**Re: CDR-20-004- Sterling Ranch – Sand Creek Channel Third Submittal Comment R**

Please see the JR Engineering comment responses to the third submittal comments made on December 14, 2021 by El Paso County. The comment responses are in red italics.

01	R=120.00' L=36.89' Δ=17.62°	02	R=120.00' L=95.00' Δ=45.36°	03	R=120.00' L=250.76' Δ=119.73°
04	R=100.00' L=70.17' Δ=40.21°	05	R=200.00' L=52.76' Δ=115.11°

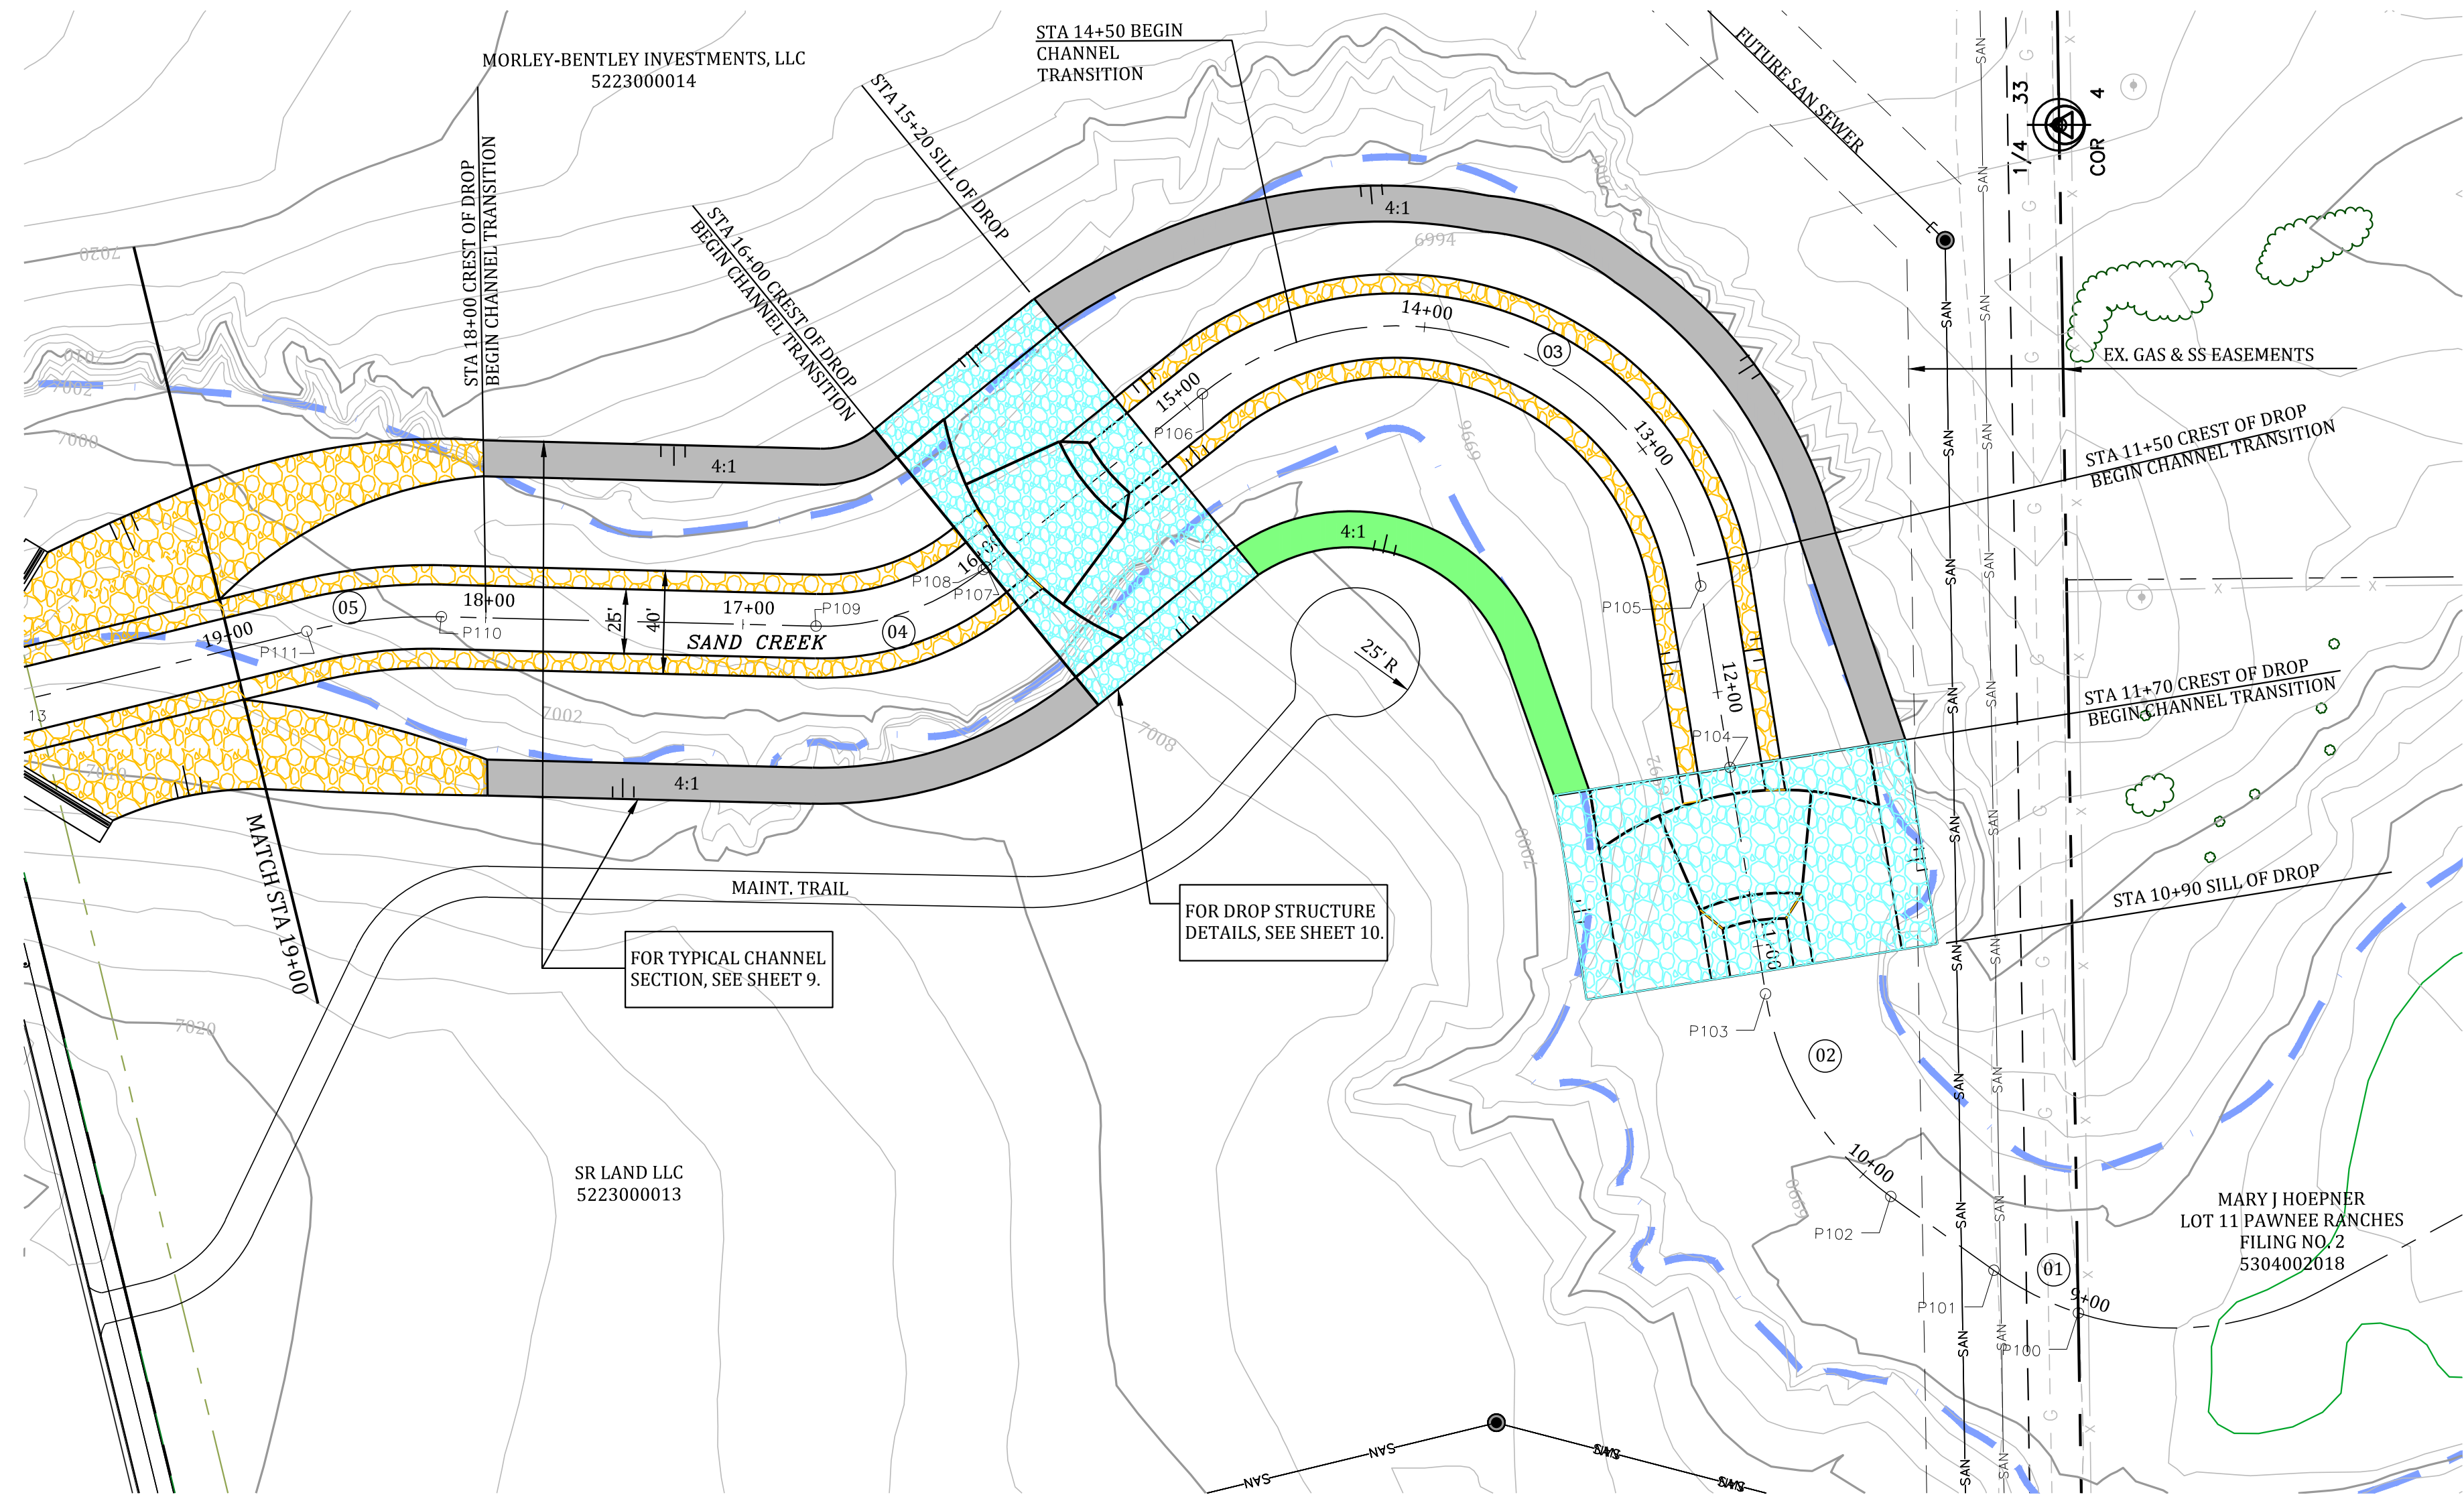
5. Per ECM Section 3.3.3.E.2, the minimum radius of curvature of the centerline of a channel shall be at least 2 times the top width of a trapezoidal channel to minimize development of spiral flow. This requirement does not appear to be met in multiple locations; revise as appropriate (all radii of concern were not redlined). **Unresolved.**

*Response: JR's design criteria was initially based on recommendations by a hydrogeomorphologist. The criteria called for centerline radii between 2.5 and 3.5 times bankfull width.*
